**Application by North Somerset District Council for an Order granting  
Development Consent for the Portishead branch line – MetroWest Phase 1**

**Issue Specific Hearing 2, Day 1, Monday 11 January 2021**

**Response to Action Points**

**Agenda item 4 - Permanent Public Right of Way Diversions and Alternatives**

NATIONAL CYCLE NETWORK
ROUTE 26 OVERBRIDGE
CROSS SECTION PLAN LAYOUT
ROYAL PORTBURY DOCK ROAD

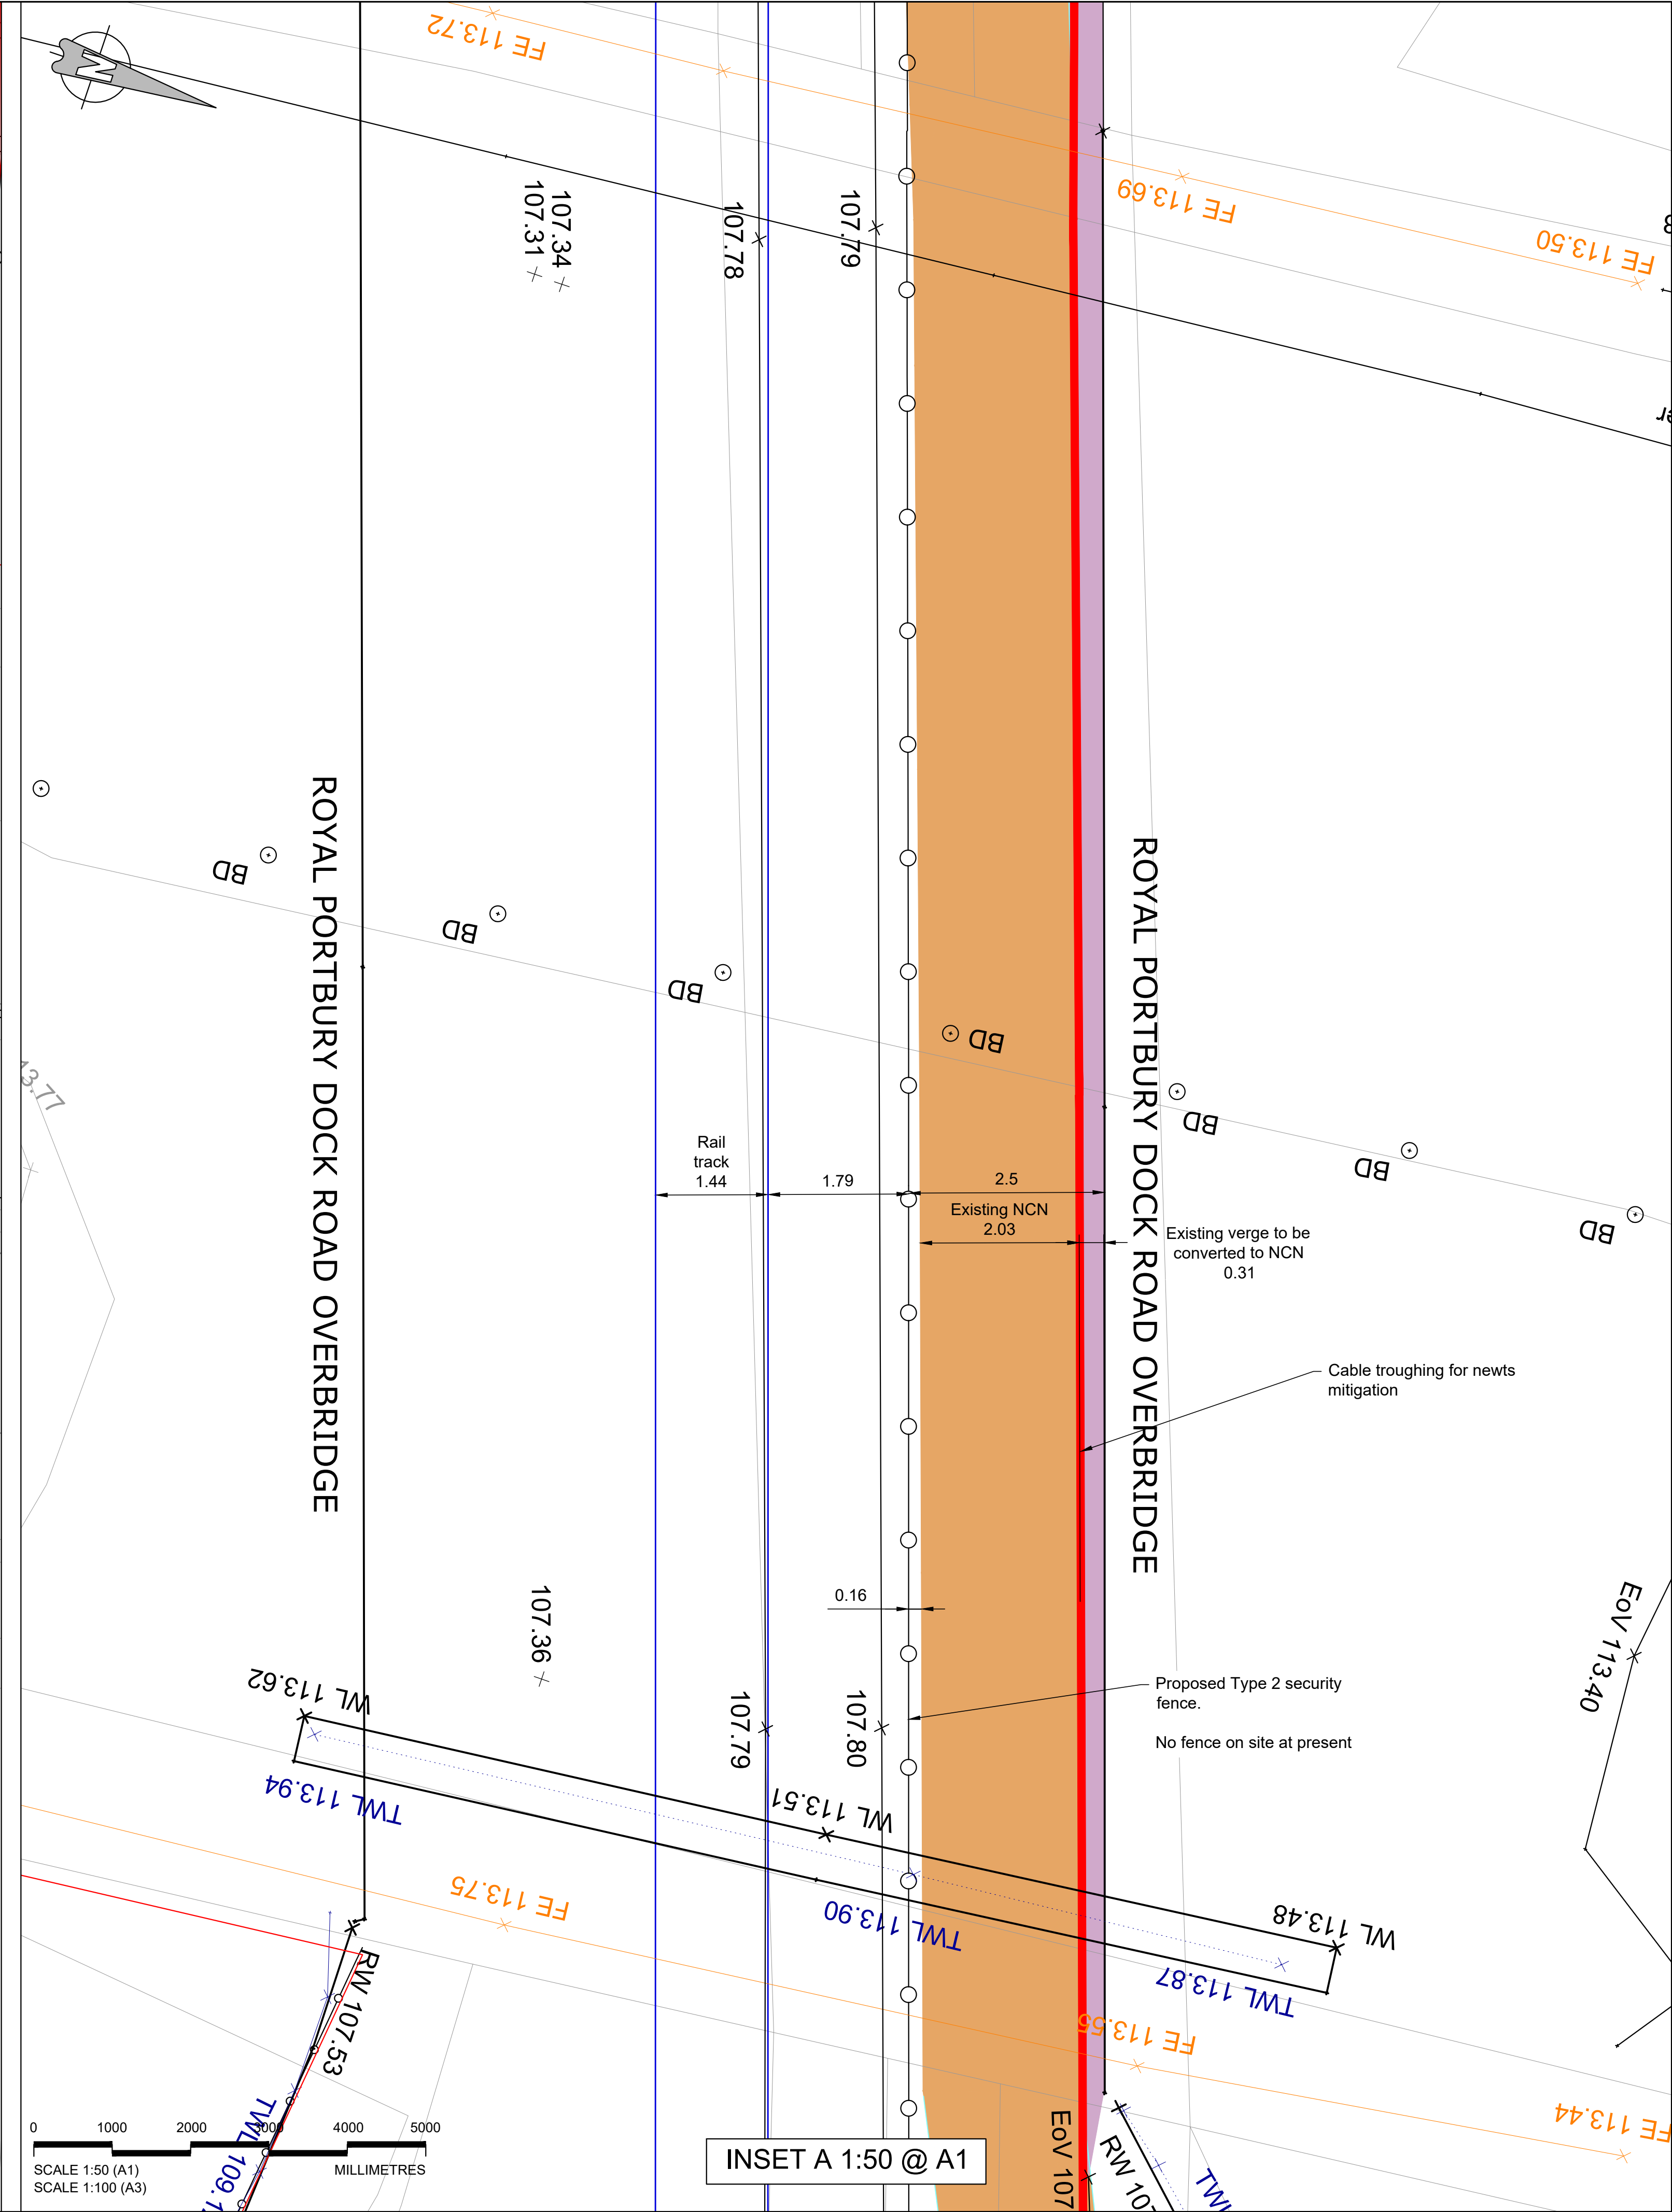
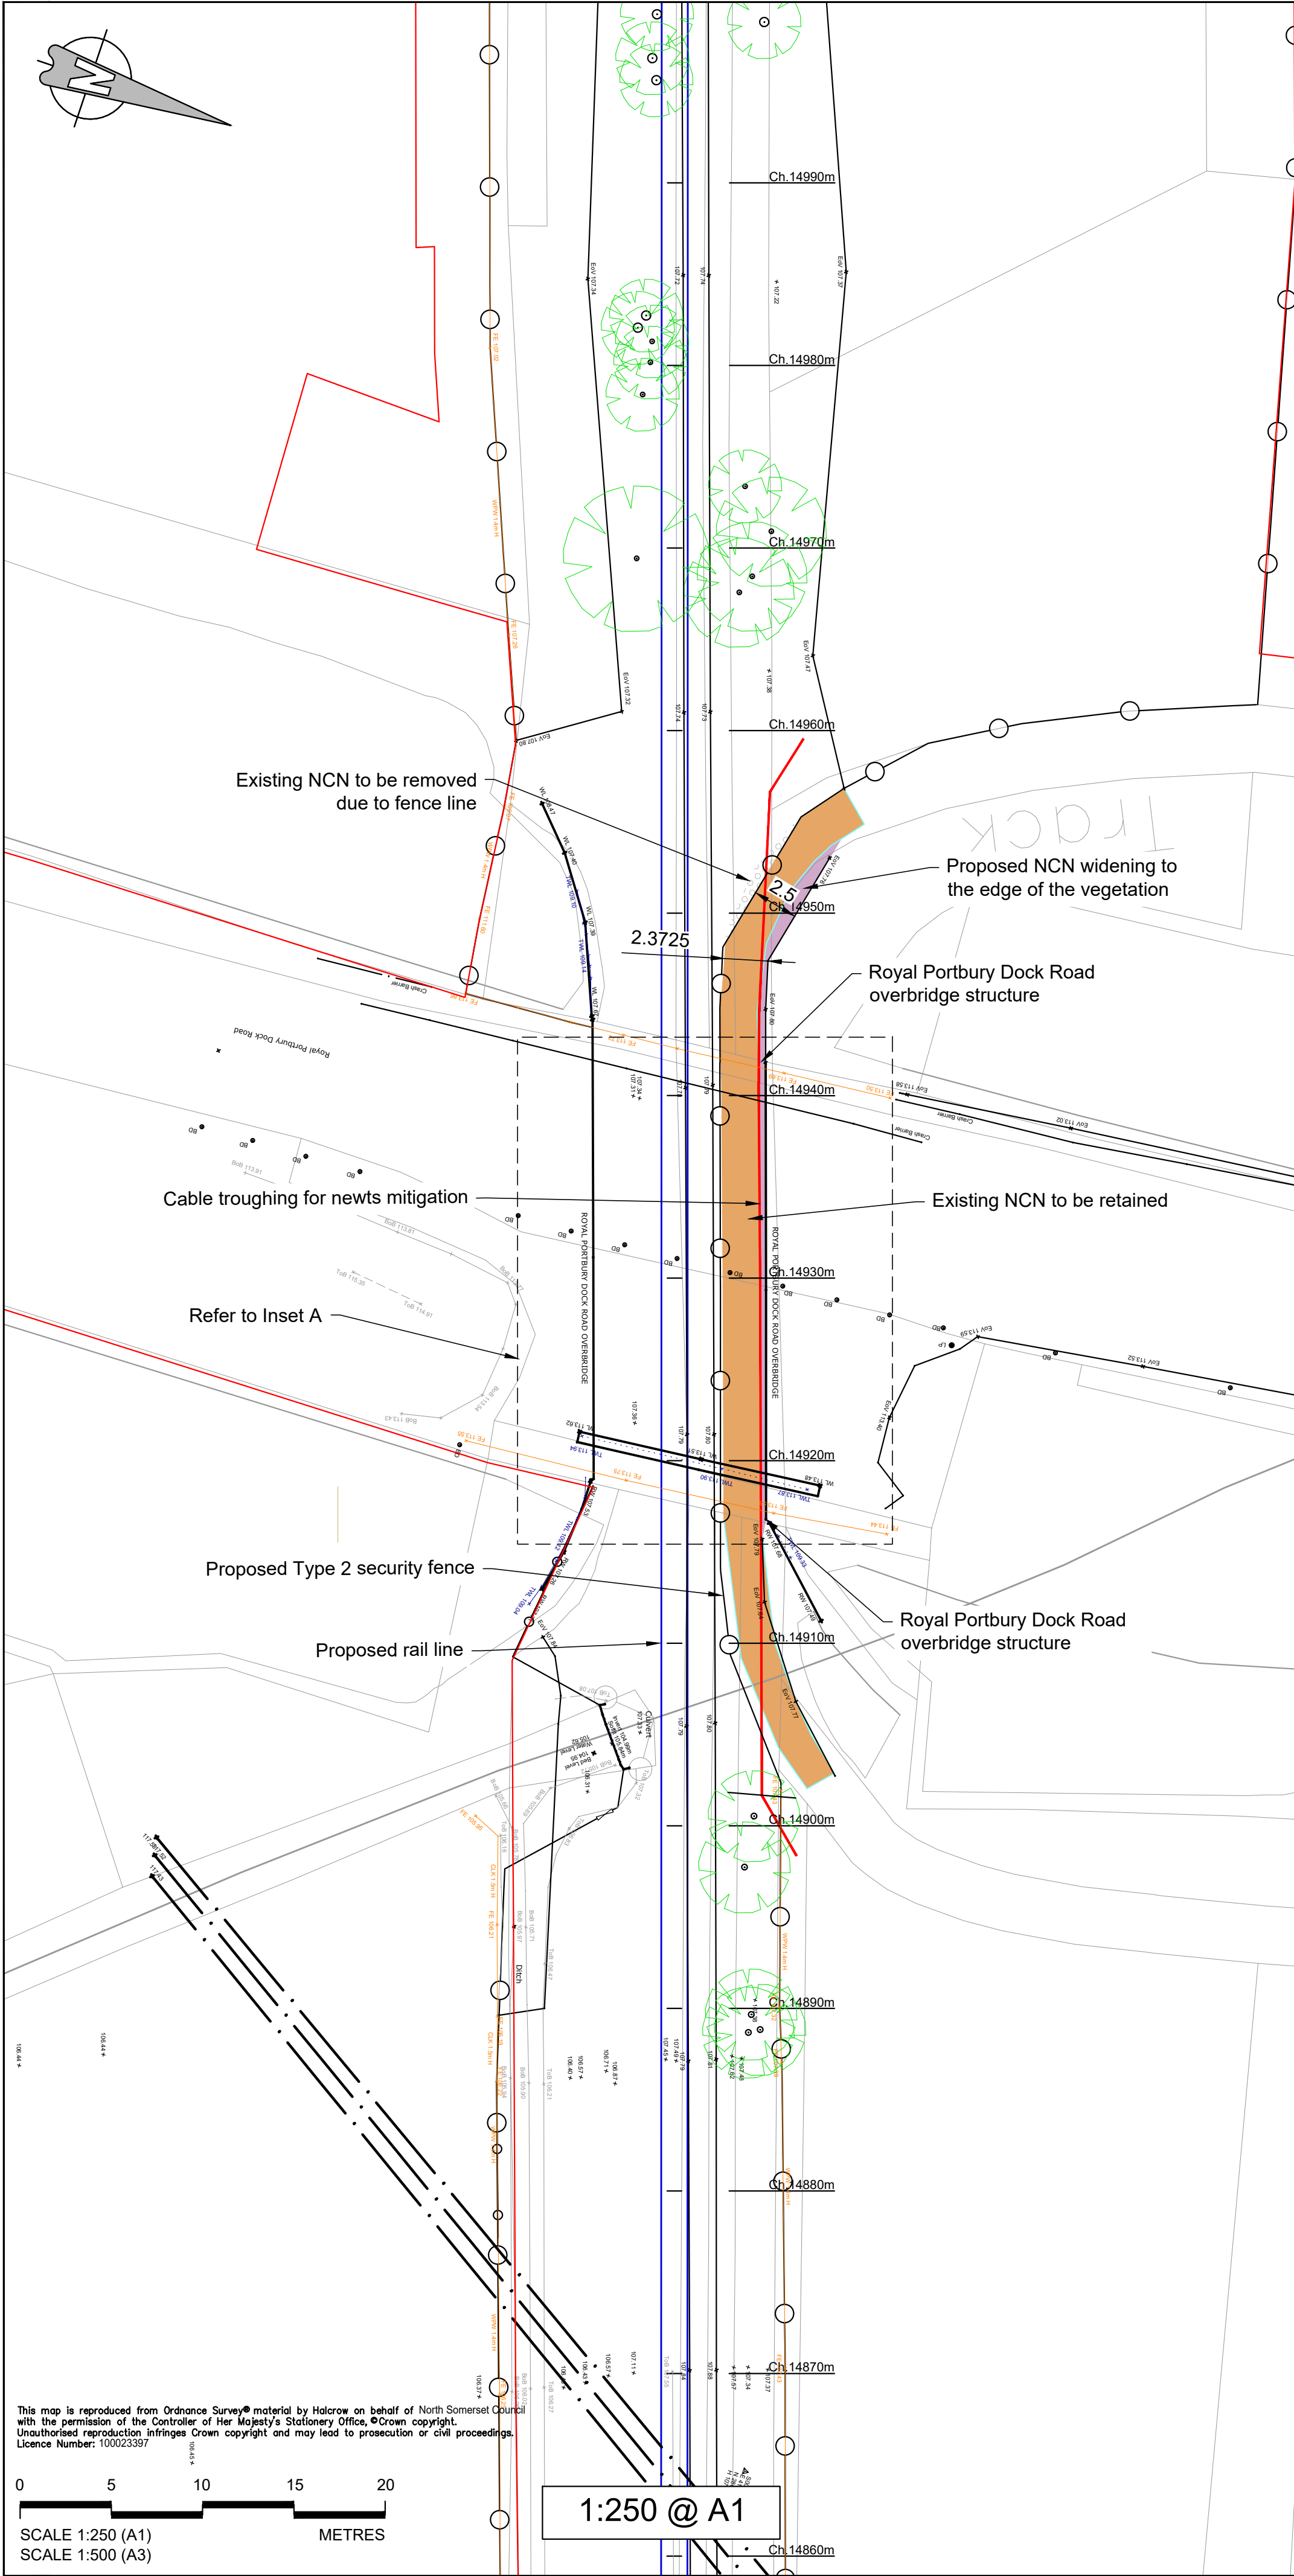
I have been in further contact with Mr Ovel. We share the opinion that as per the potential need for an acoustic barrier between the public footpath and the M5 underbridge, the same need applies the underbridge at **Royal Portbury Dock Road** (Works No. 14B); as the needs here are no different to those at the M5 underbridge, albeit I estimate the underbridge to be approx. 25 metres in length.

I request that the potential need for an acoustic barrier between the public footpath at the underbridge at **Royal Portbury Dock Road** is therefore taken in to scope and given likewise consideration.
